From: Sue Howell
Sent: 27 February 2019 17:13
To: Planning.Responses
Cc: Michael Eastham
Subject: RE: Please find attached amendment on planning application Ref: WA/95/18/RES

Comment from Greenspace

APPLICATION NO: WA/95/18/RES

Site Address: Land east of Tye Lane Walberton

PLAY & RECREATION DIAGRAM

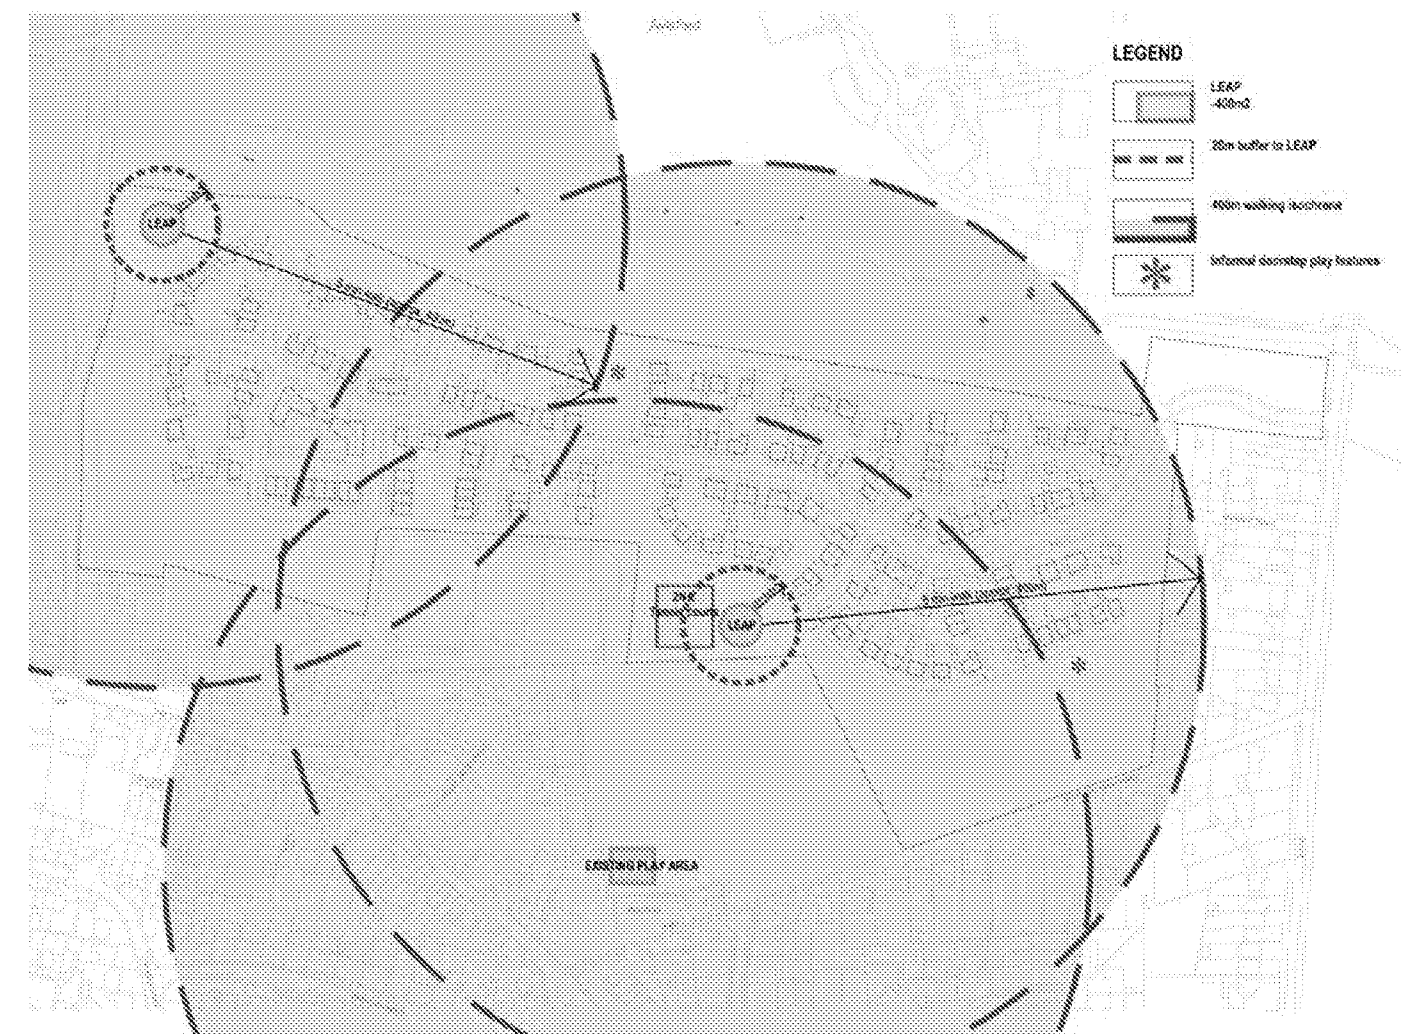
Further to submission of additional information re landscaping contained in dwgs 3823-101-111 Rev A and supported in letter ref LHU/P18-1110 I can confirm that the detail has addressed the issues raised and the design changes that were discussed.

We can confirm ADC's support of the change in detail from MUGA to Tennis Court (Parish maintained) and note the proposed footpath amends to support both this and the LEAP play areas. The outstanding query would be for confirmation to be provided of footpath surfacing in these areas; which would be assumed to be a tarmacadam finish as opposed to the more informal pathways through the grassed POS areas?

I can confirm that subject to the confirmation and approval of pathway finish requested above, I would therefore recommend approval of the landscape detail contained in this reserved matters application WA/95/18/RES following outline consent WA/44/17/OUT.
